**KIRKLEES METROPOLITAN COUNCIL
INVESTMENT & REGENERATION SERVICE**

DELEGATED DECISION TO DETERMINE PLANNING APPLICATIONS

Reference No:	2023/62/91323/W
Site Address:	42, Benomley Drive, Almondbury, Huddersfield, HD5 8LX
Description:	Demolition of existing rear extension and erection of single storey side and rear extension
Recommending Officer:	Tom Hunt

Officer Report

Project: 42 BENOMLEY DRIVE ALMONDBURY	Job No: 2021-014
Title: PROPOSED PLANS & ELEVATIONS	
Scale: 1:50@A1	Drawn by: AP
Date: 08.04.21	Checked by: -
Drawing No: 2023-004-(20)002	Revision No: A

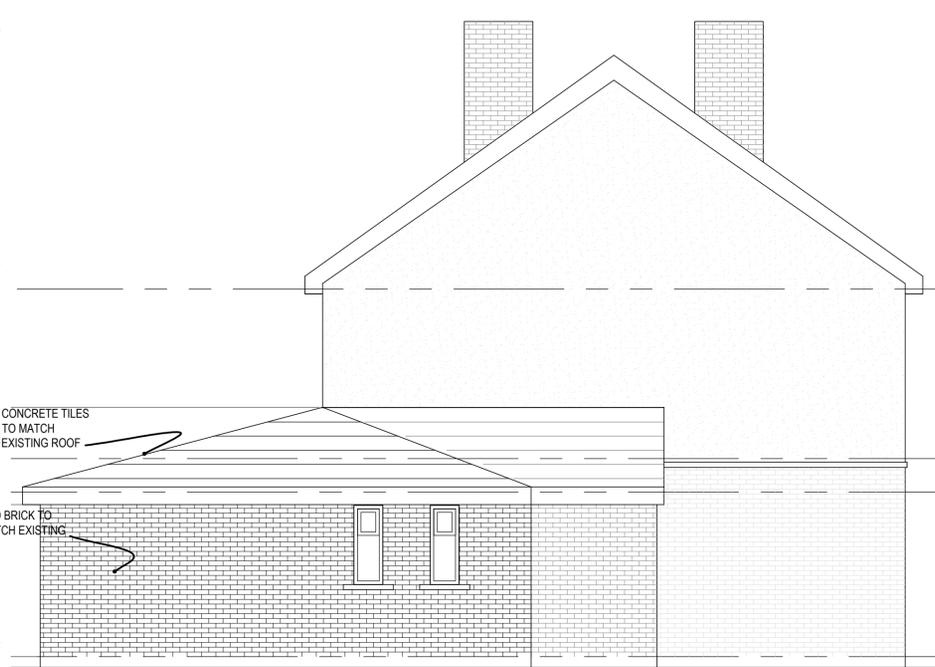
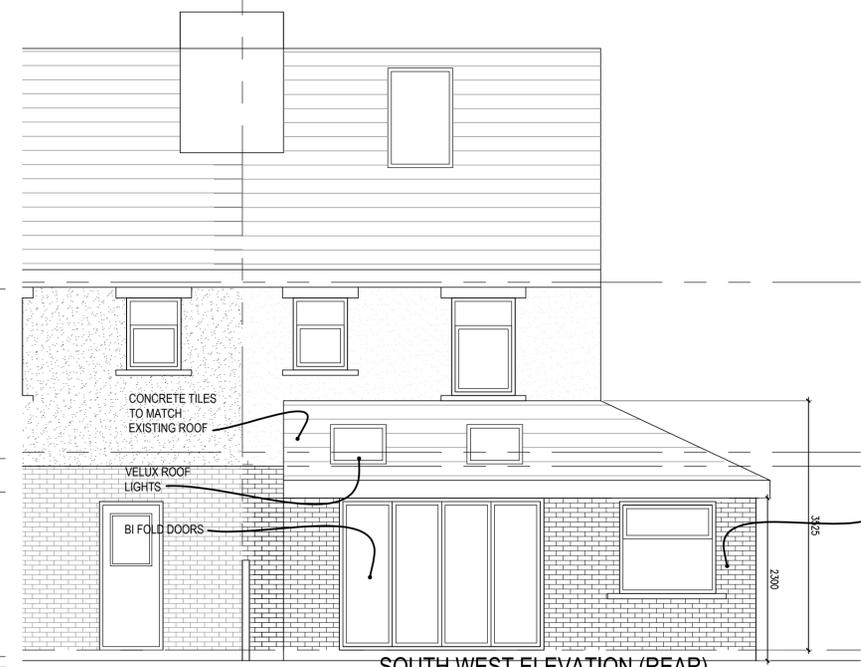
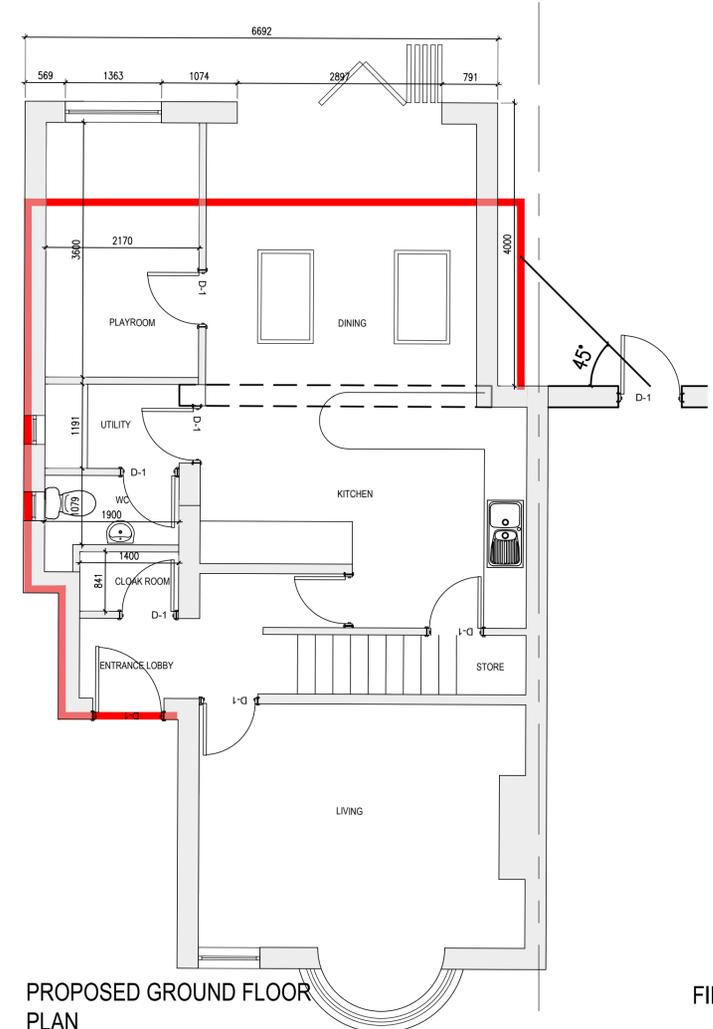
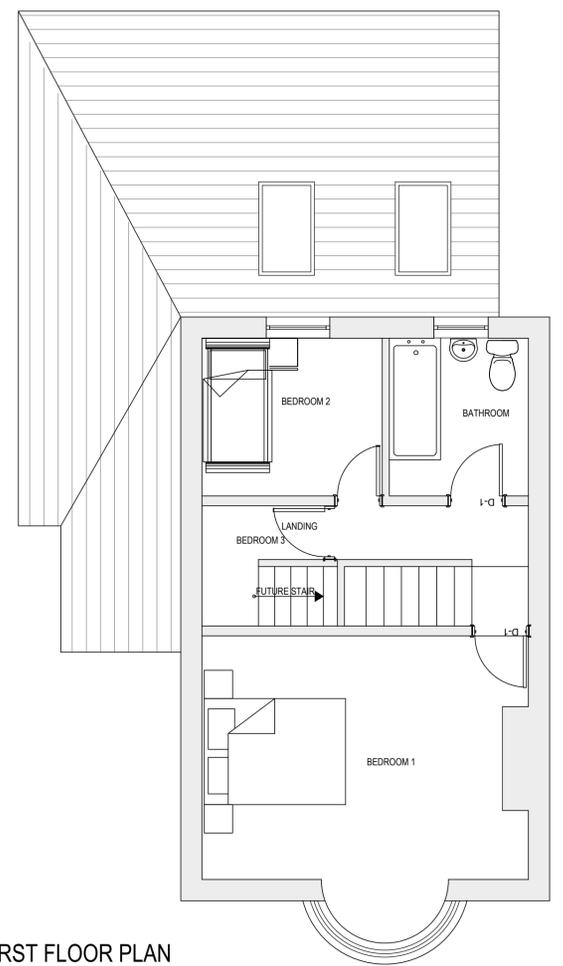
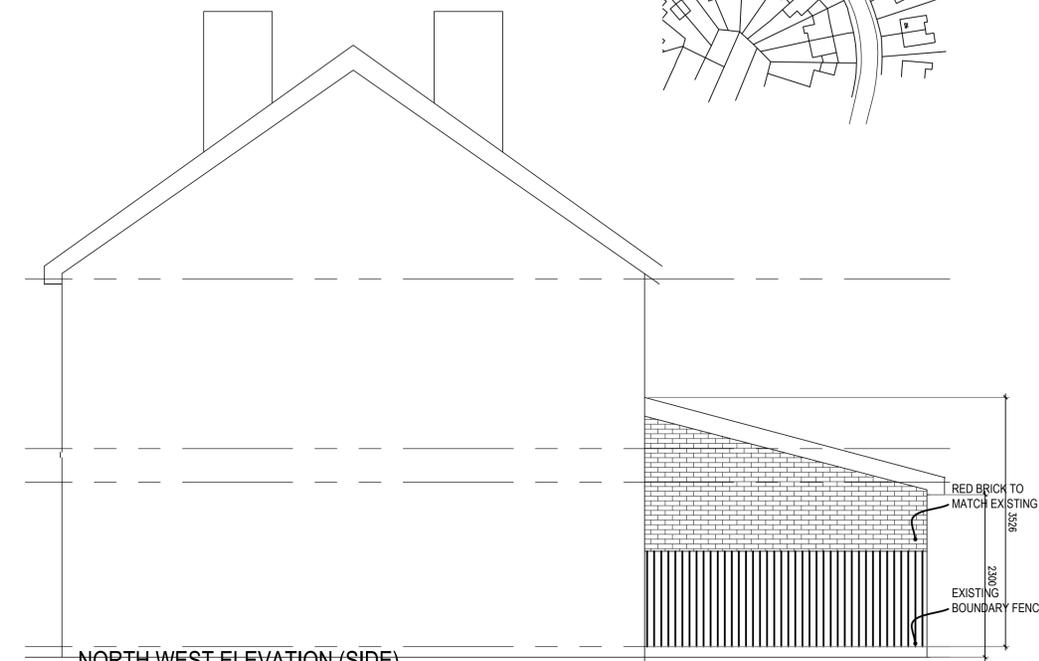
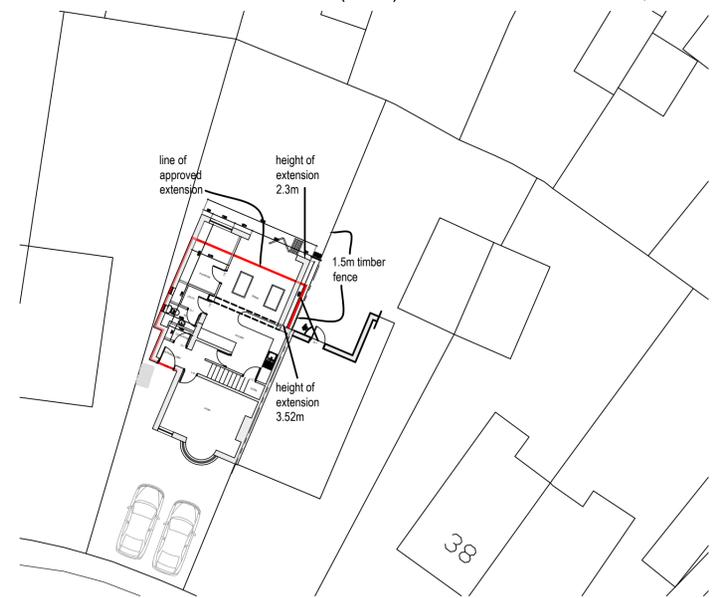
It is proposed to demolish the outrigger and conservatory to make way for a side/rear wraparound, single-storey extension. This new extension would be set back 3.5m from the primary elevation of the host. It would appear as a stepped side extension projecting 1.7m from the side (with depth of 1.7m) then a maximum 2.2m projection from the side extending beyond the rear elevation of the host by 4m and at the rear it would be 5.592m width. The rear element would be set away from the shared boundary of the attached neighbour by 0.5m.

It would have a doorway to the front, two narrow windows to the southwest side elevation and bifolds and large window to the rear only. The roof would be pitched with a mix of lean-to and hipped design, with two skylights to the rear roof elevation.

The roof ridge height would be consistently 3.7m for the side and rear elements, and the eaves height would be a range of 2.6m-2.85m from ground level with part of the side extension being the highest.

Officer Note: Measurements vary from the plan annotation for roof ridge height and eaves from ground level provided as they follow official Govt. guidance on measurement of height from ground level (not FFL) and how to measure eaves for Permitted Development Rights, i.e., *“from ground level at the base of the outside wall to the point where that wall would meet the upper surface of the roof slope.”*

It would be set behind the host and while it would be projecting beyond the sides, the wrap around design would be fully compliant with the design guidance for single-storey side extensions and be considered acceptable.

The rear extension would not block access however it is acknowledged that the side extension element would block access to the garden. It is noted that the extant application no. 2021/91779 had approved a similar arrangement, and it is recommended that this be accepted to be consistent with previous decision making.

It would project 4m from the rear replacing a single-storey rear extension of 2.8m projection from the rear. It is noted that application no. 2021/91779 approved a single-storey rear extension of 2.7m projection from the rear with a setback of 0.3m from the shared neighbour boundary (northeast). The proposal seeks to reduce this impact by having a set back of 0.5m from the boundary and positioned next to an existing doorway would not appear visually overly obtrusive. Officers recommend that this be acceptable, in this isolated case, on balance. This includes the fact that there are no habitable room windows impacted in the neighbouring property, there is only a door.

Considering impact to No. 44, the side extension would bring the host dwelling closer to their shared boundary with two narrow windows facing them; currently there is a door and window facing No. 44's side elevation which in turn has a door and large window facing No. 42's side elevation. The proposed windows would serve a W.C. and utility room, it is considered that it is necessary to have a condition to fit obscure glazing to those windows to prevent overlooking and loss of privacy. The side extension would be set back considerably from the primary elevation and set down rooflines which would not risk terracing or detrimental overbearing impact. As the extensions would be positioned to the northeast, their orientation would not lead to detrimental overshadowing impact. Although it projects further than the previous permission, it is now single storey only.

4. The W.C and utility room window in the northwest side elevation, shall be non-opening or top-opening only and shall be fitted with obscure glass to give a grade 5 degree of obscuration before the development is first brought into use. Notwithstanding the provisions of section 55(2) (a) (ii) of the Town and
